Application Ref:	2026/0288			 Ribble Valley Borough Council <small>www.ribblevalley.gov.uk</small>				
Date Inspected:	26/06/2025	Site Notice:	N/A					
Officer:	EP							
DELEGATED ITEM FILE REPORT:					APPROVAL

Development Description:	Non-material amendment to application 3/2025/0455 involving proposed garage to be re-located away from adjoining boundaries.		
Site Address/Location:	Carniola Whins Lane Simonstone Lancashire BB12 7QT.

PROPOSED PLANS AND ELEVATIONS

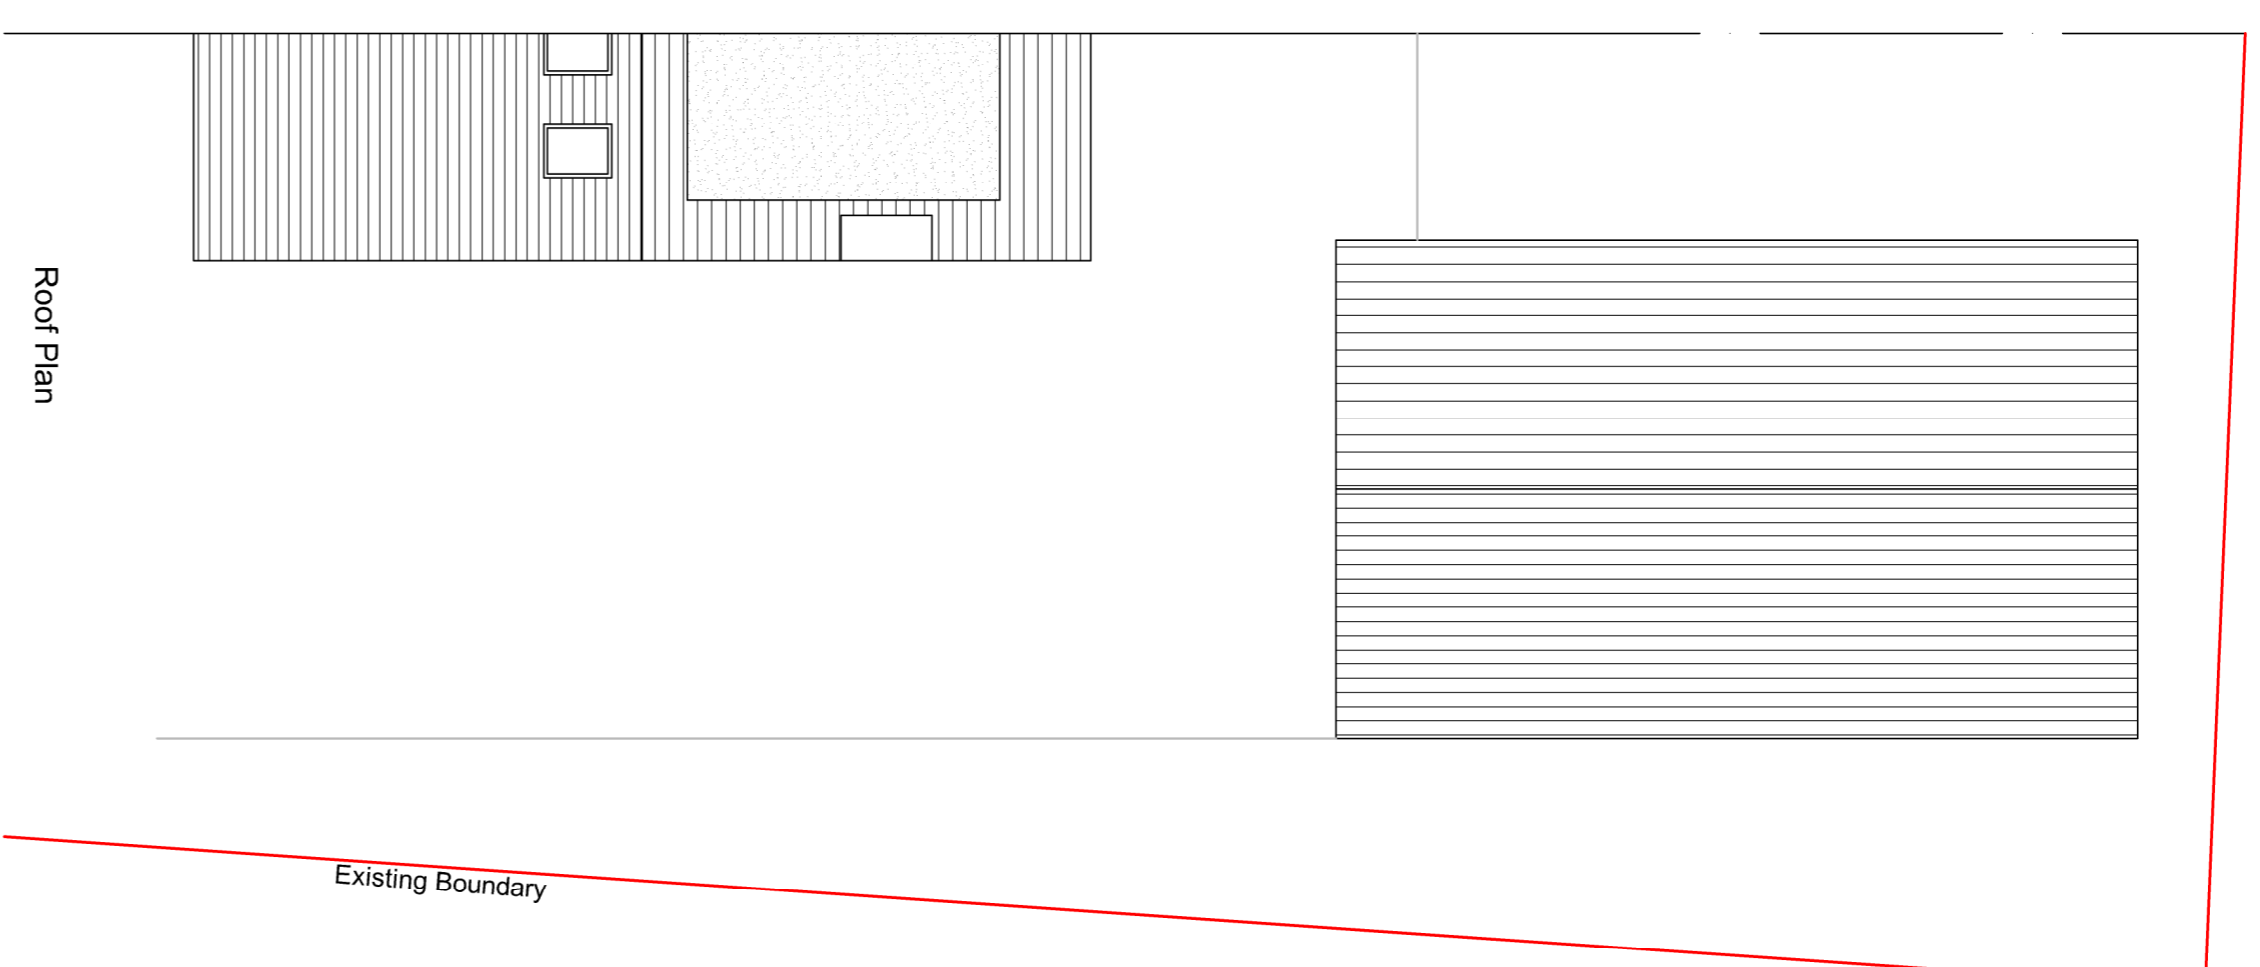
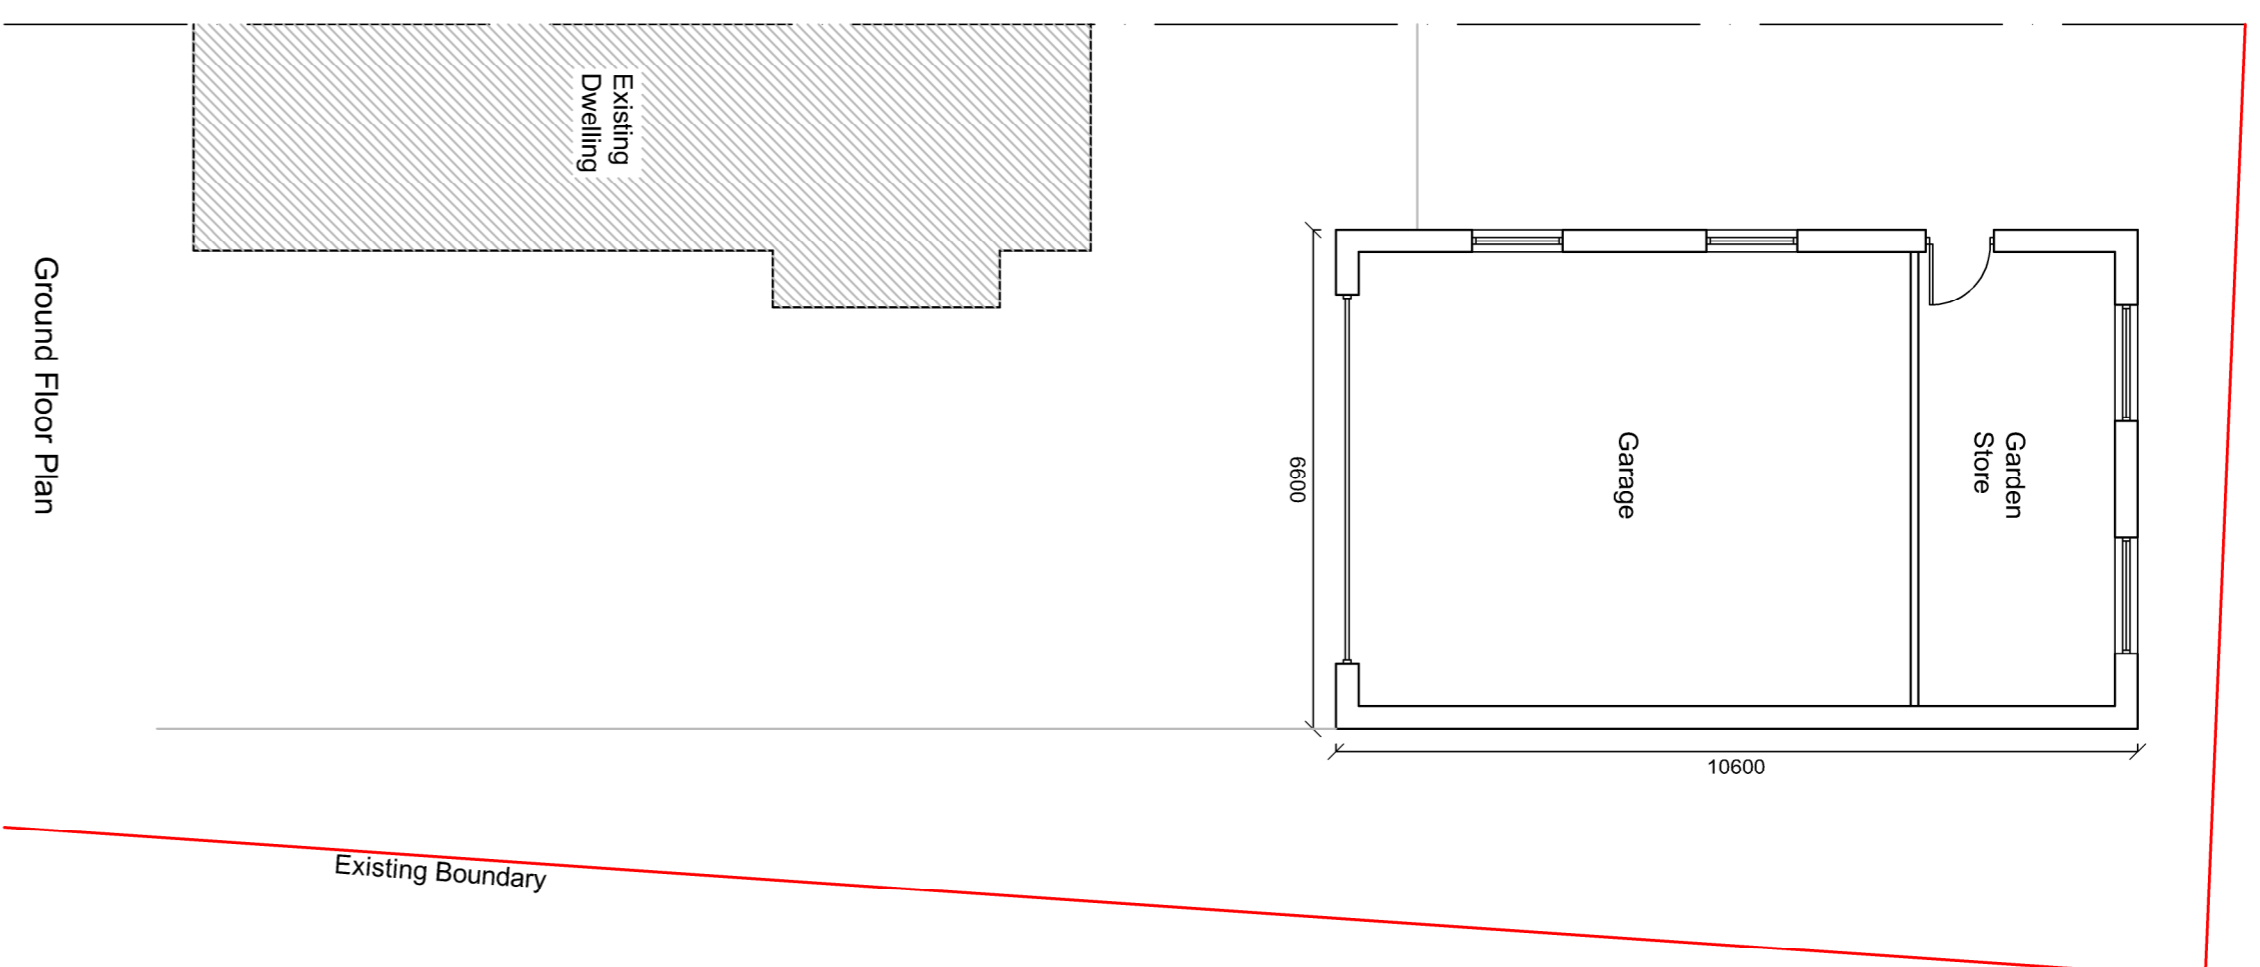
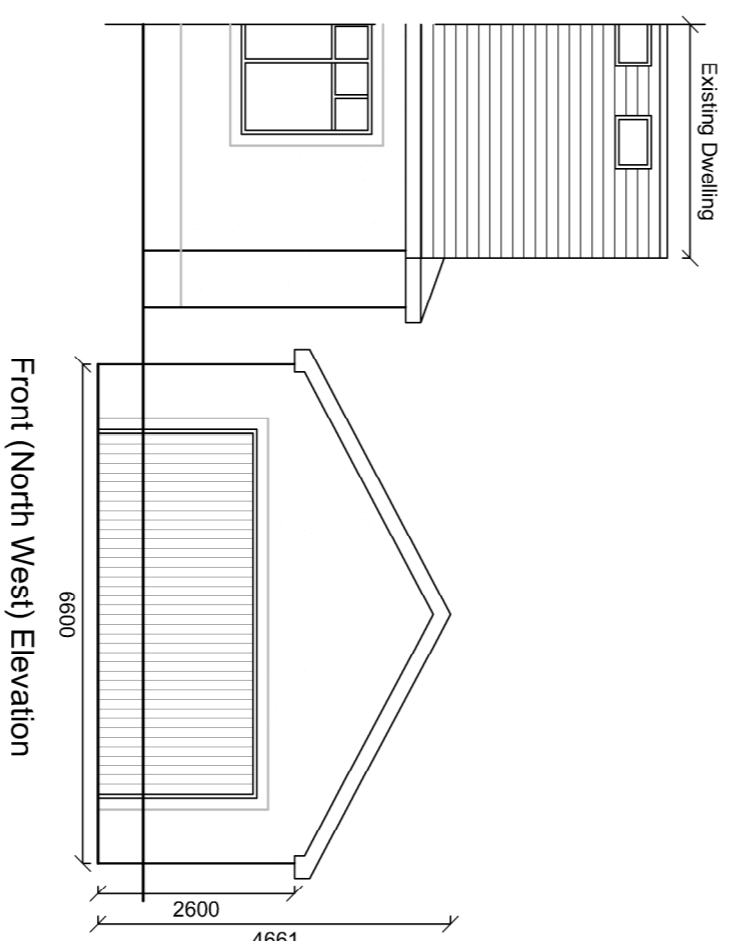
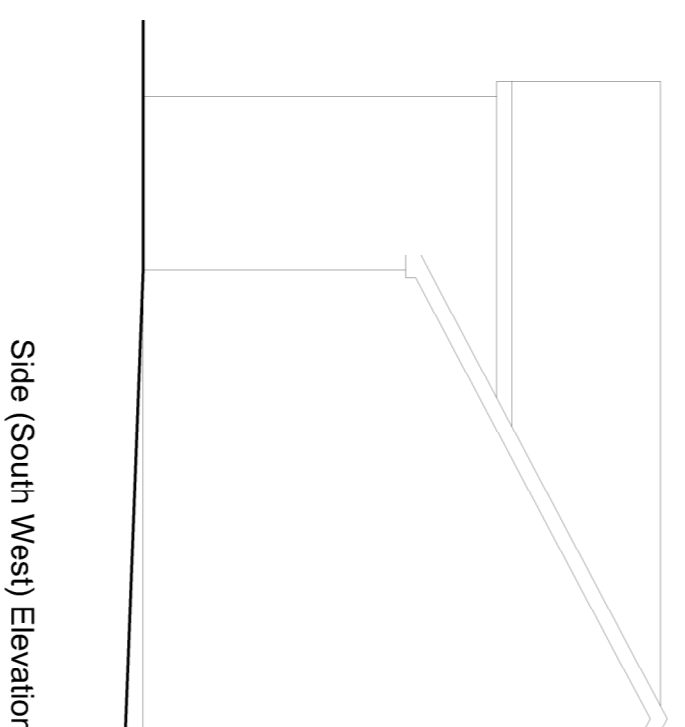
The amendment sought involves the slight relocation of the approved garage so that it is set away from the boundary by approximately 500mm allowing the retention of the existing boundary treatment. The application also seeks to include two window openings in the rear elevation of the garage. These alterations are modest and do not materially change the visual appearance of the garage given the siting of the garage is largely consistent with the previous approval and the window openings are sited to the rear elevation out of site from within the public realm. There are no neighbours to the rear of the site that could be impacted. As such, the proposed change is non-material in nature and considered acceptable.

That the non-material amendment be approved.
